March 3, 1998

**RE: SCOTT'S FENCING CO. (C17-D13F). ENGINEER'S CERTIFICATION FOR
CERTIFICATE OF OCCUPANCY APPROVAL. ENGINEER'S CERTIFICATION
DATED 2-25-98.**

**RE: SCOTT'S FENCING COMPANY (C17-D13F). GRADING AND DRAINAGE PLAN FOR
BUILDING PERMIT APPROVAL. ENGINEER'S STAMP DATED JUNE 16, 1997.**

RE: GRADING & DRAINAGE PLAN FOR SCOTT'S FENCING CO (C-17/D13F) ~~5~~
RECEIVED MAY 16, 1997 FOR BUILDING PERMIT & S.O.19
ENGINEER'S STAMP DATED 5/16/97

SCOTT'S FENCING COMPANY
GRADING AND DRAINAGE PLAN

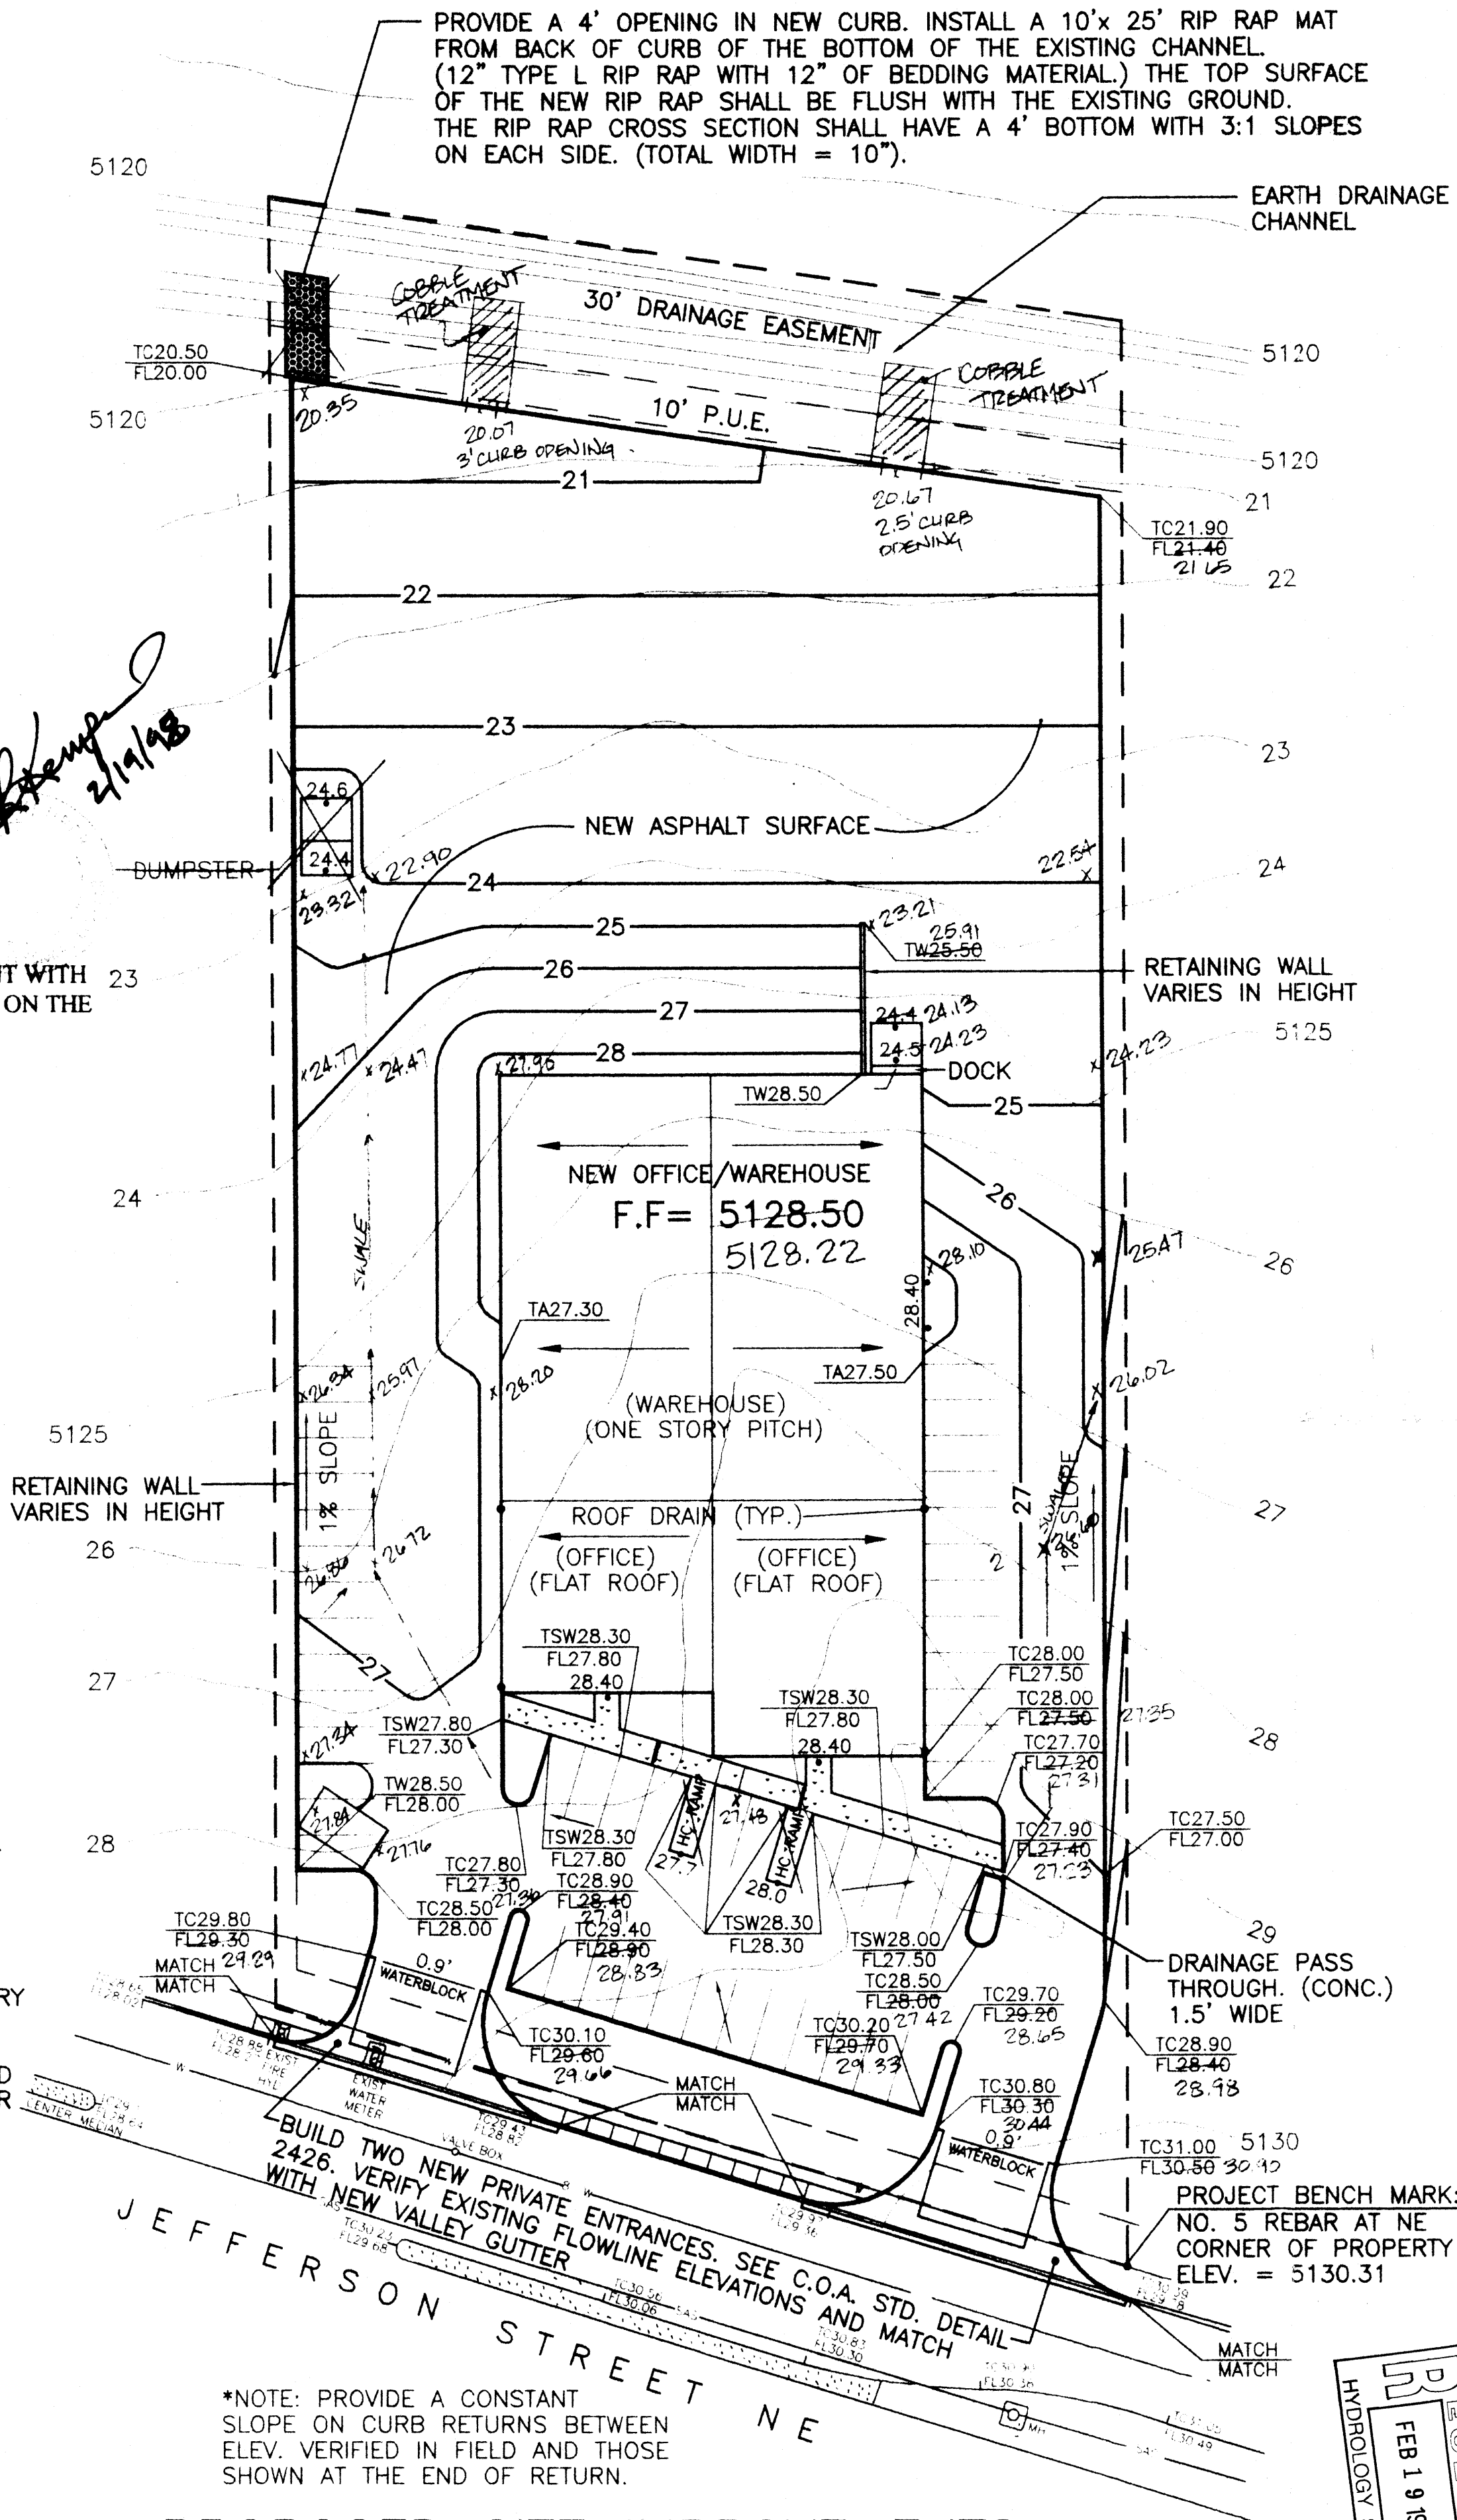
The Plan must address the issues of off-site flow & downstream capacity. The master plan for this area is "Drainage Report for Lots 1-15, Unit V, Loop Industrial District" prepared by Gordon Herkenhoff & Assoc in November 1981. This report is in hydrology file (C-17/D13) on micro-film. Plate 20 indicates that the earthen channel that drains Lots 1-11 (area = 16.2 ac) has a capacity of 76 cfs. This would prorate to an allowable discharge of 4.6 cfs/ac. This report also indicates that the easement is private and the property owner is responsible for the maintenance of the channel. It would clarify what the signature block is for, if it was titled "S.O.19 for Private Entrances".
